From: Laura Gibbons <Laura.Gibbons@arun.gov.uk>
Sent: 24 August 2021 15:42
To: Planning.Responses <Planning.Responses@arun.gov.uk>
Cc: Simon Davis <Simon.Davis@arun.gov.uk>
Subject: RE: Planning Consultation on: Y/112/21/DOC

Application No: Y/112/21/DOC

Site Address: Stakers Farm North End Road Yapton BN18 0DU

Description of Works: Approval of details reserved by condition imposed under Y/44/17/OUT relating to conditions 7-drainage strategy, 8-proposed surface water drainage & 9-Suds maintenance system.

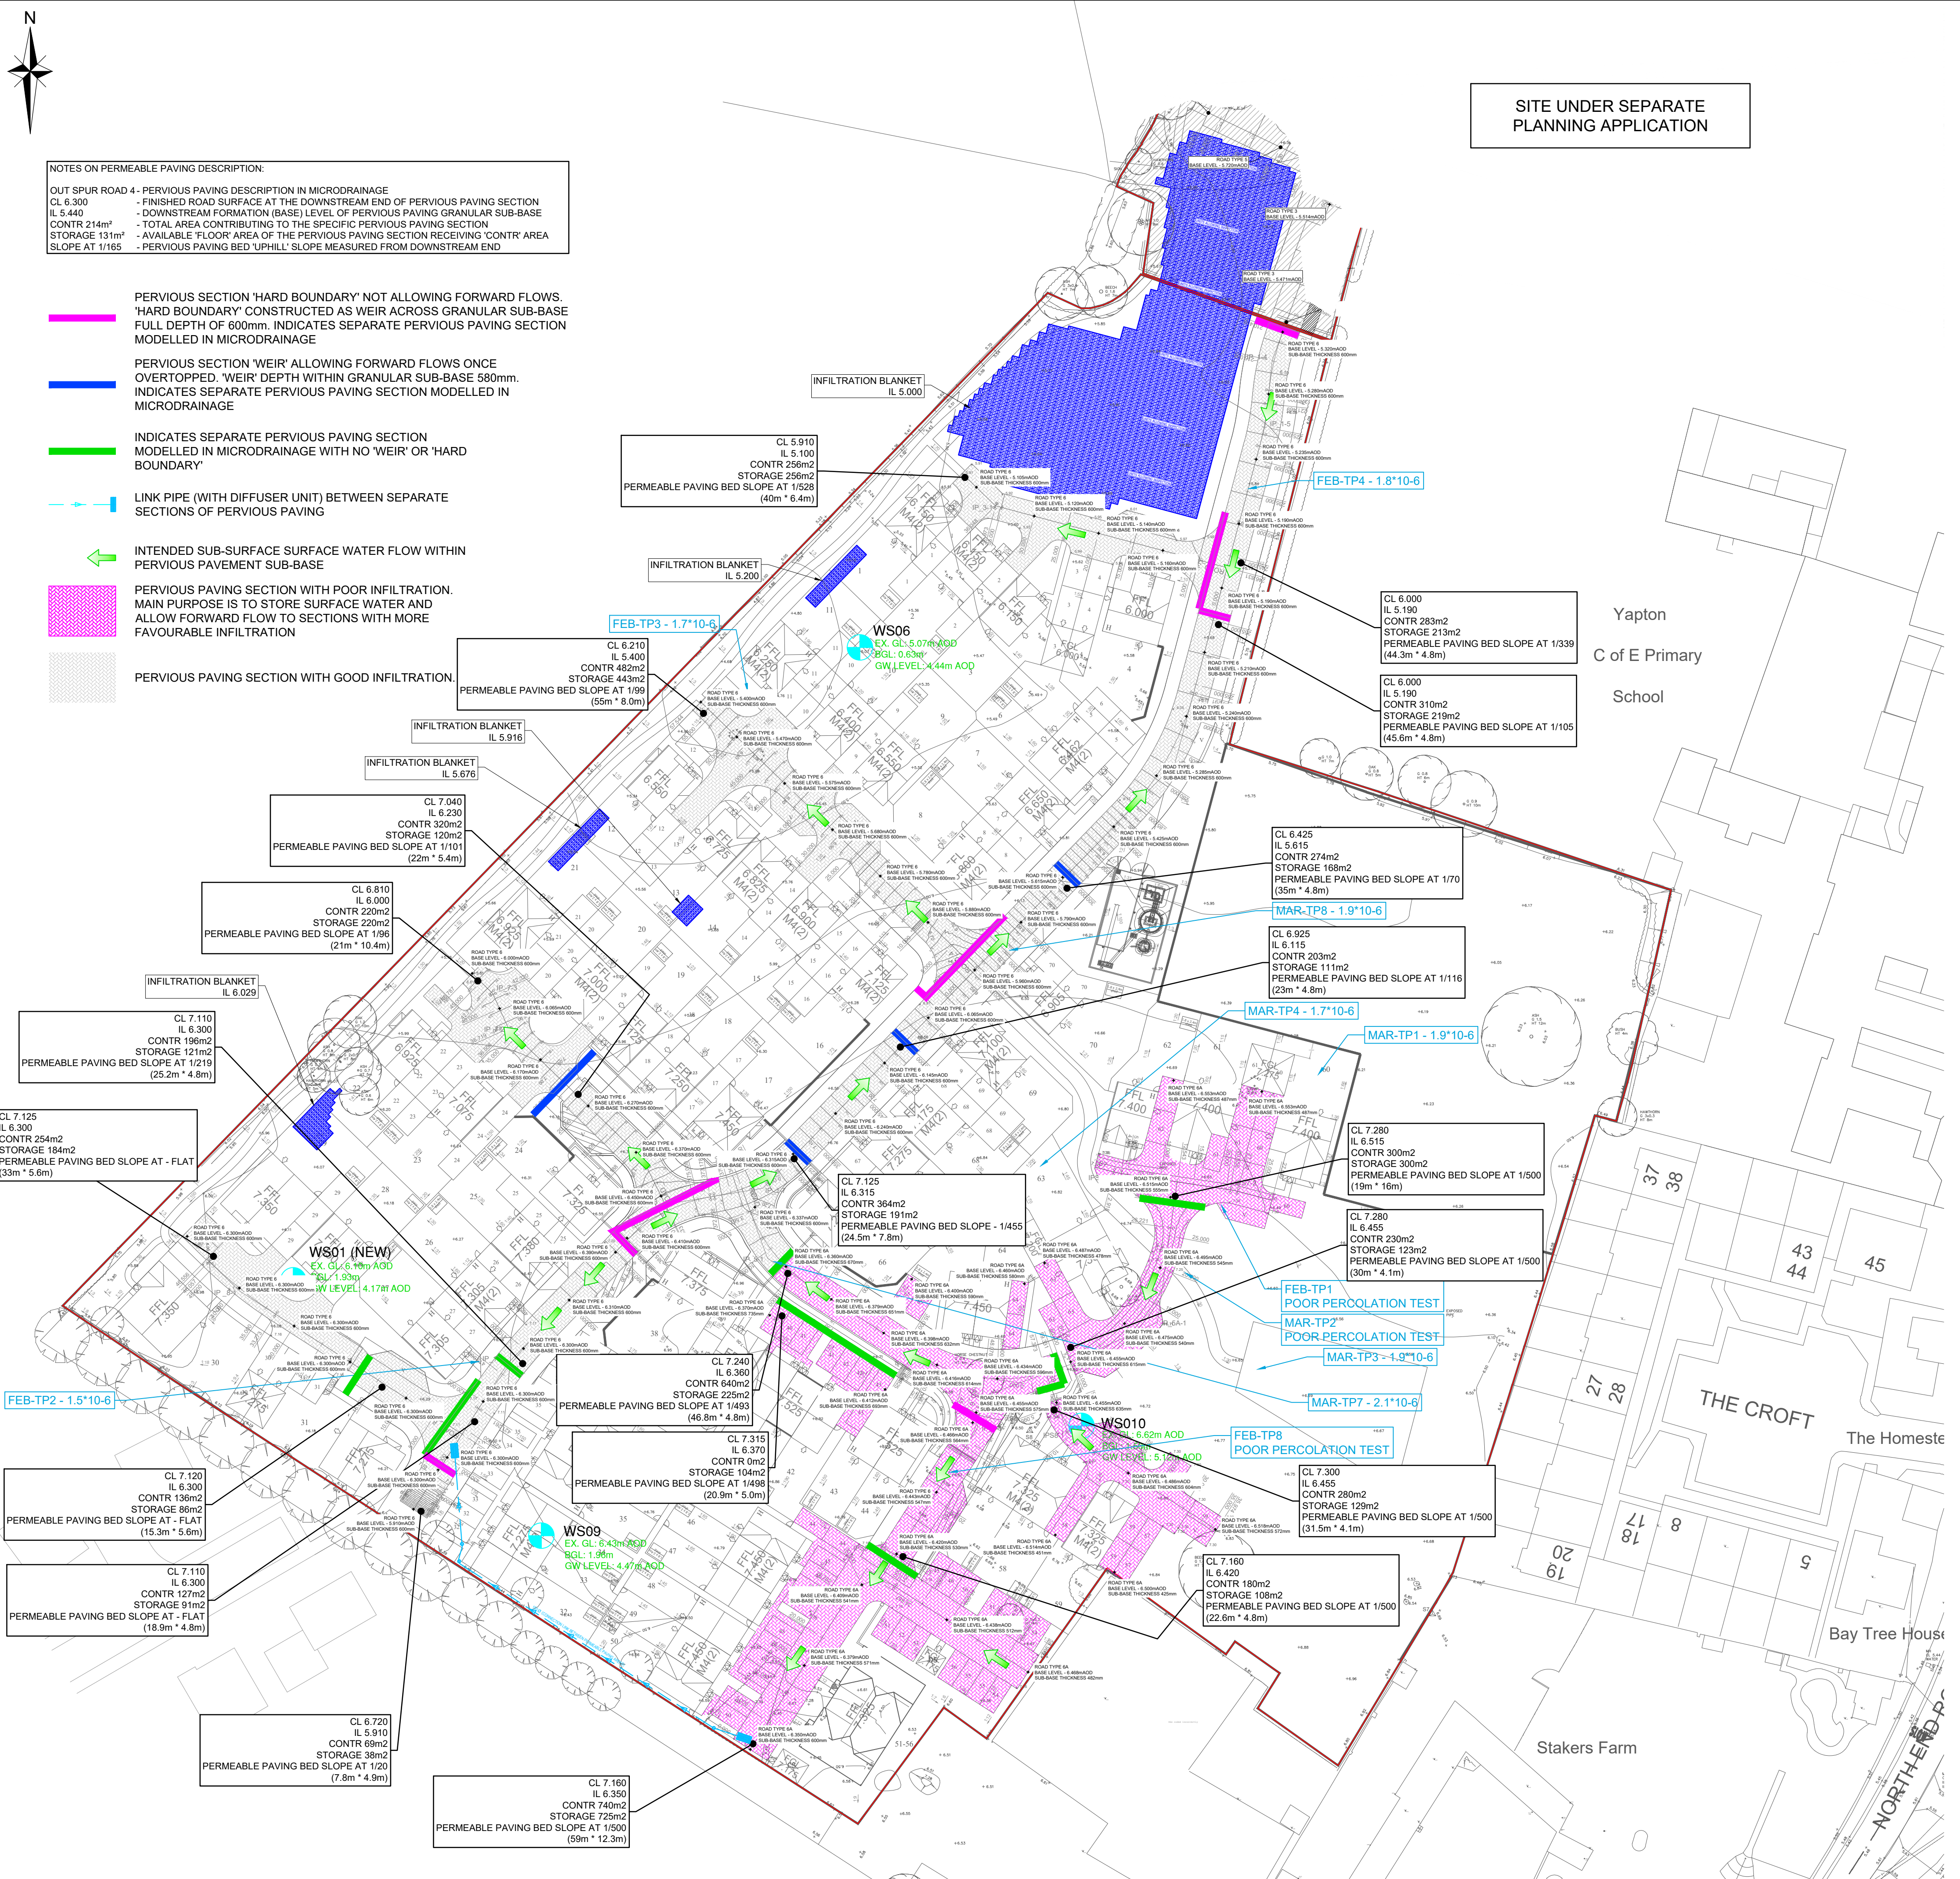
Minimum sub-base construction depths need to be provided on plan and finish and formation spot levels need to be reviewed to ensure minimum sub-base depths are provided throughout.
